DEVELOPMENT PLAN MEADOW LAKE HANGAR

8140 CESSNA DRIVE
PEYTON, COLORADO 80831

FILE NO: FPR-21-038

TITLE SHEET

DP-2
 2 OF 10

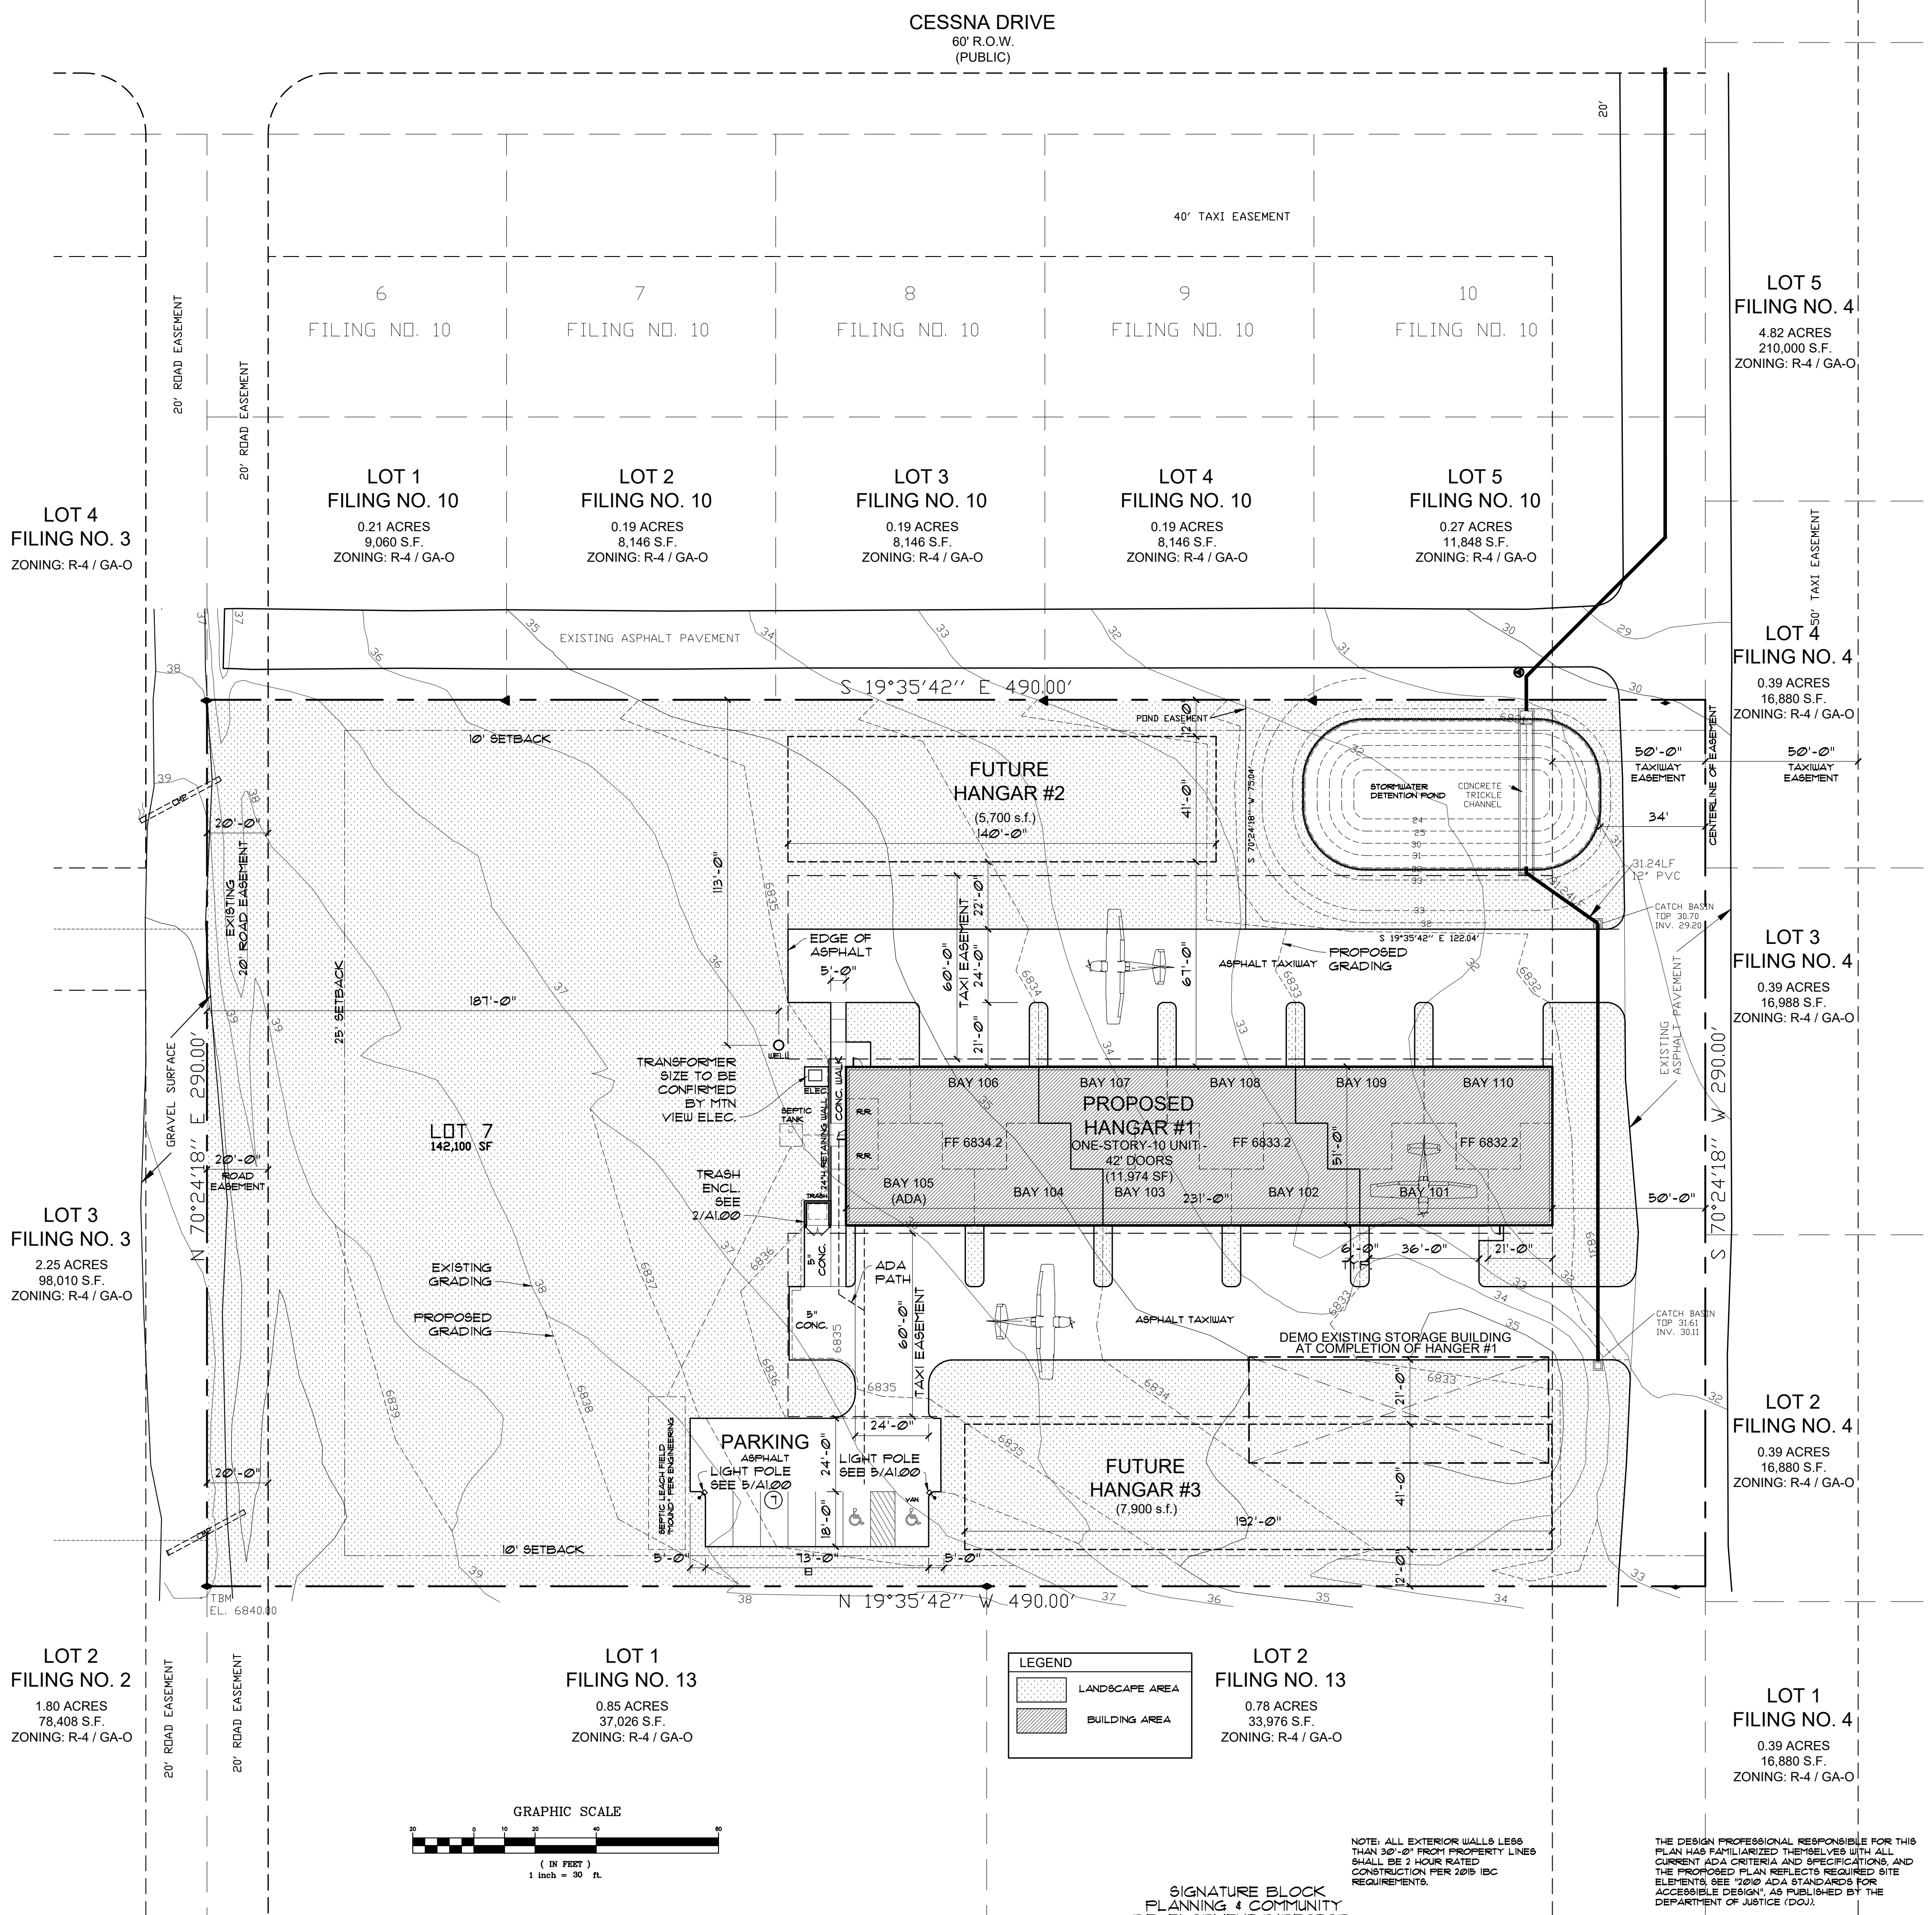
Future hangars noted - please be aware that you will need to include them in lot calculations and likely provide for drainage measures in order to qualify for commercial over the counter permits in the future. Otherwise, when you come back to permit those future buildings, you may be subject to another site development plan review and may need to retrofit drainage facilities to support the additional impervious area.
